From: Carol Ansbro <carroll.ansbro@gmail.com>
Sent: 11 October 2018 11:33
To: planning
Subject: The application is to extend existing practice bays with four-sided shelter to house two golf simulator studio No 3/2018/0822

Thornley with Wheatley PC has considered this planning application and wishes to make the following comments/observations

Proposed Plans and Elevations

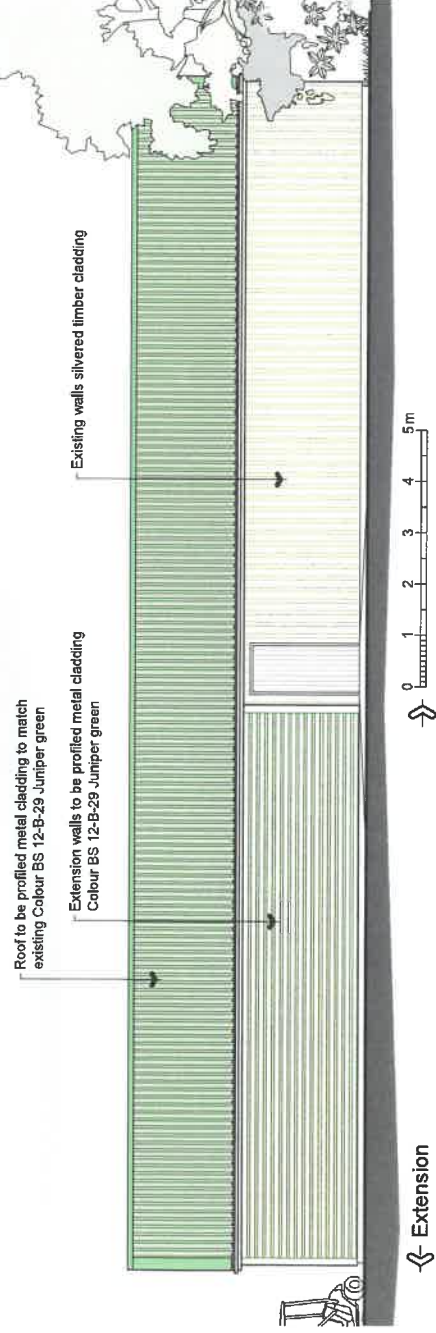
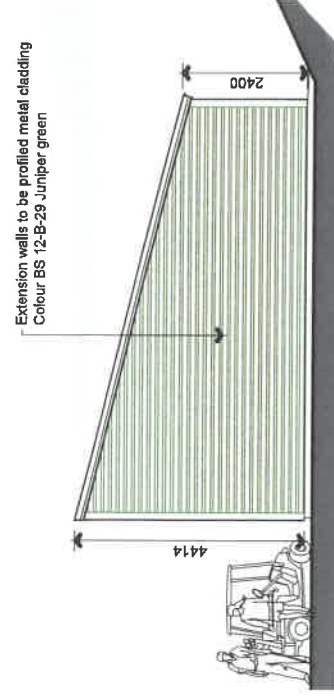
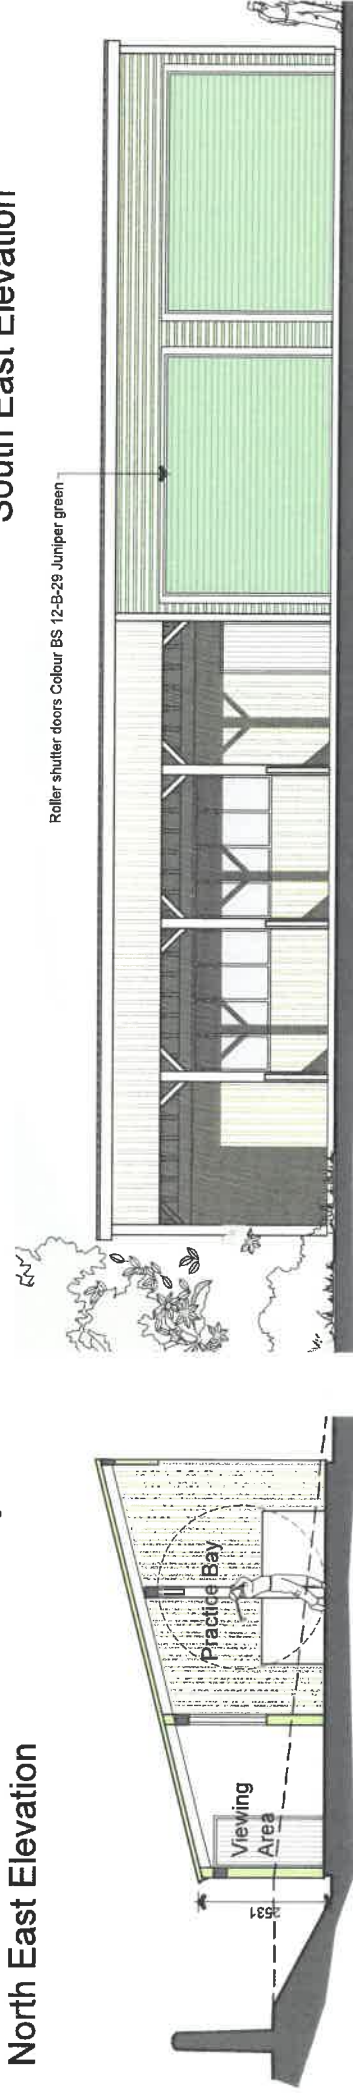
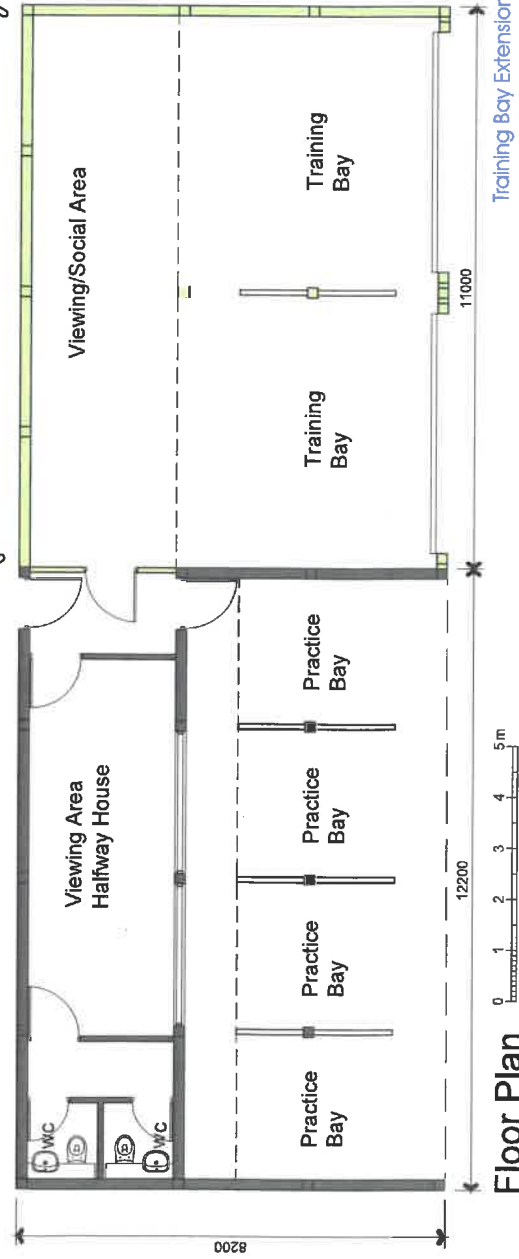
- The existing Golf Practice Bay Shelter is a substantial building which is very evident on the landscape being situated high on Jeffrey Hill and even more prominent when illuminated as it is most evenings
- The proposed extension would substantially increase the visual impact in this rural location. Th design indicates that this structure will be enclosed and we therefore assume it will not add to the light emissions
- The existing roof of the Shelter is finished with profiled metal cladding - colour Juniper Green and the walls are vertical over-lapped timber boarding. The plan of the extension shows that both walls and roof are to be finished in metal cladding therefore visually different to the existing building
